CITY OF ALBUQUERQUE

June 3, 2019

RE: **Winrock Road Town Center**
2100 Louisiana Blvd NE
Drainage Master Plan- Drainage Implementation Plan
Engineer's Stamp Date: 5/23/19
Hydrology File: J19D058

Based on submittal received on 5/29/19, the Drainage Implementation Plan is approved for Site Plan for Building Permit.

City Project No.	4553.90	Zone Map No.	J-19-Z	Sheet	Of
				EXHIBIT 1

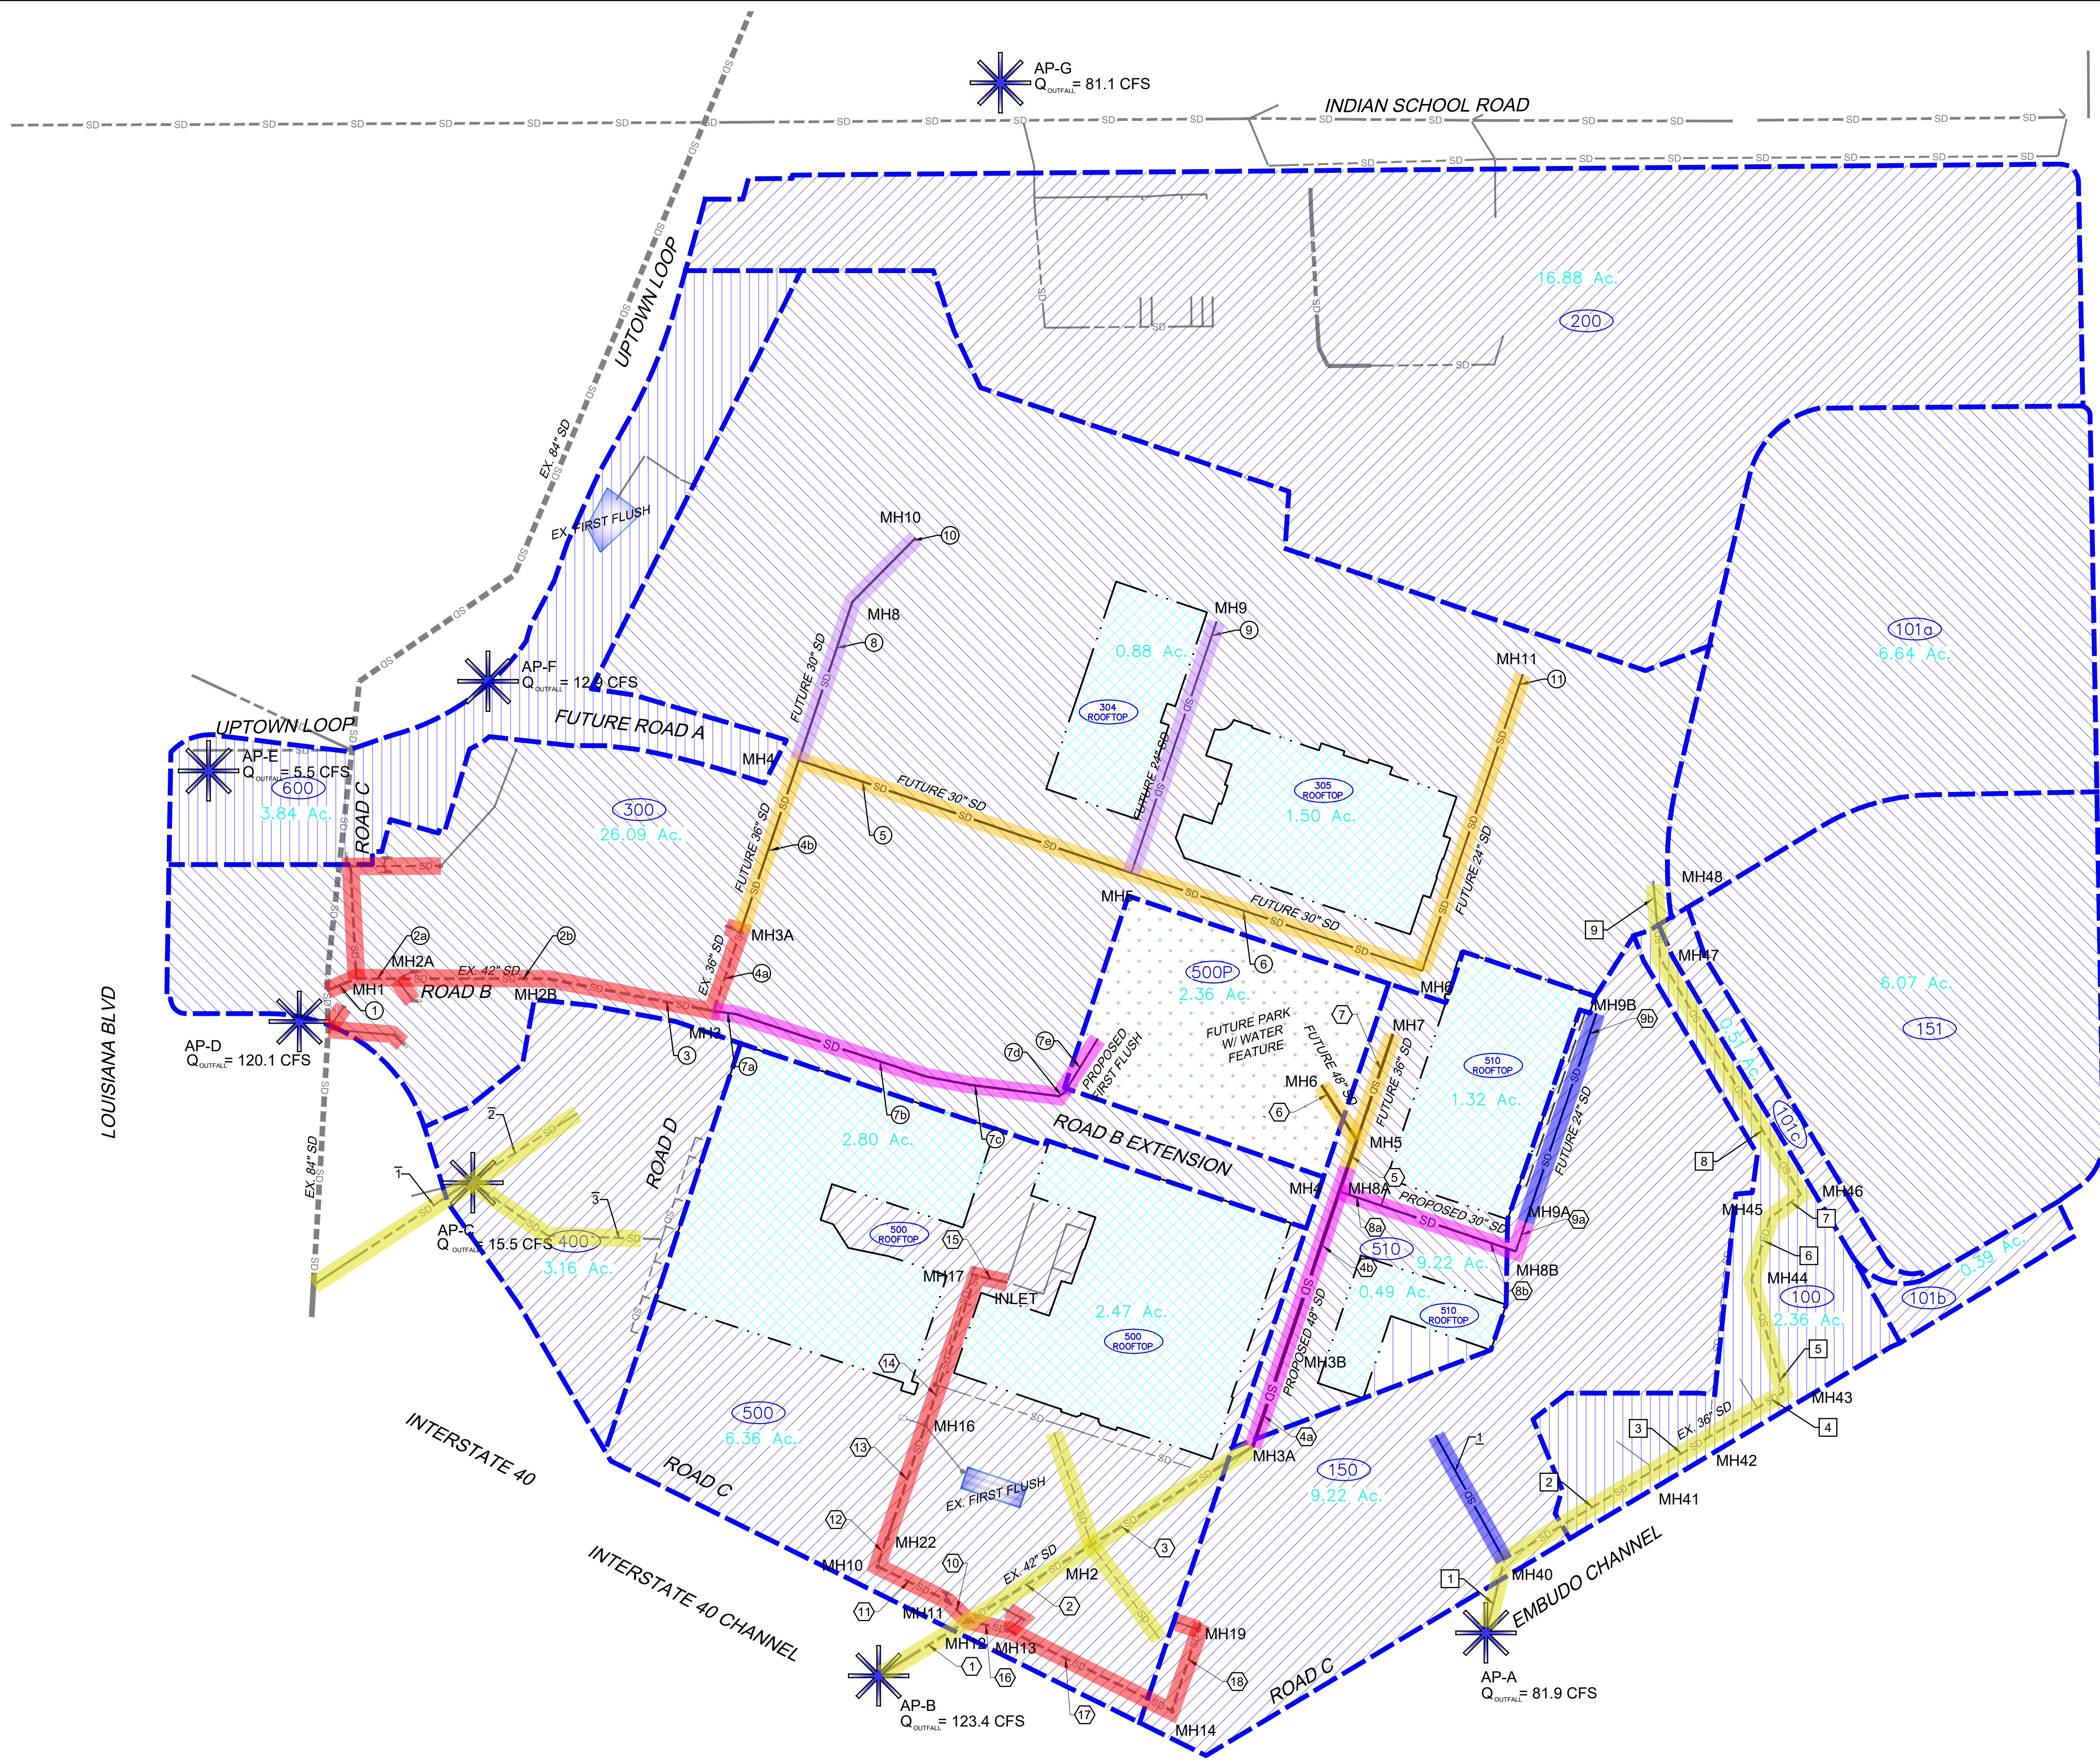
1. For Information. Include Exhibit 1 in the DRB Master Site Plan. Please check that the phases match the Architect's phases. The remaining exhibits (2-9) can remain in the DIP, so long as the master summary table is provided on Exhibit 1.
2. For Information. Prior to Work Order for each phase, a detailed drainage report will be required to detail many of the hydraulics shown in the DIP as well as address all grading and drainage criteria per the DPM, such as storm water quality and surface flow hydraulics.
